From: Farhad Khatibi
Sent: 04 February 2026 15:58
To: Planning ContactCentre
Subject: RE: Attached letter from Kirklees Council regarding application number 2026/90254 at location land at, Vanguard Processing Equipment, Spa Fields Industrial Estate, Slaithwaite, Huddersfield, HD7 5BB

Further to a review of the additional information provided, I would like to advise the following:

Bridges & Structures Manager
Structures Section
Highways and Streetscene
Kirklees Council

Title: **PROPOSED SITE PLAN**

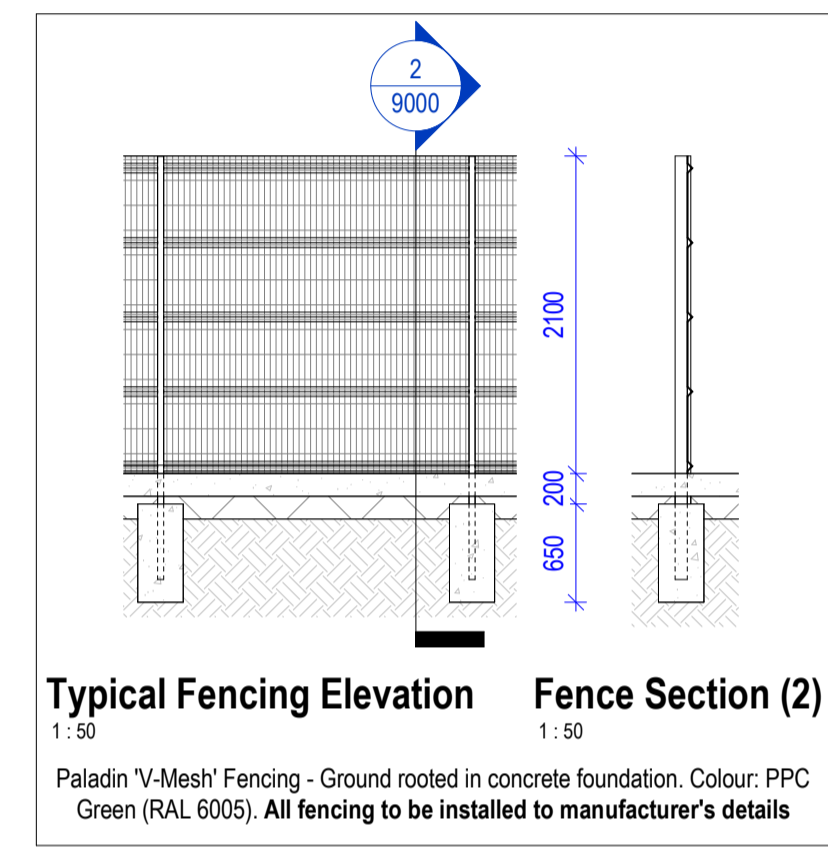
Condition 10 (retaining walls and boundary treatments details) - This condition can not be discharged pending the submission of an external works plan showing the location of the proposed building retaining walls adjacent to the highway on Spa Fields so as to determine whether their design will be liable to a formal technical approval.
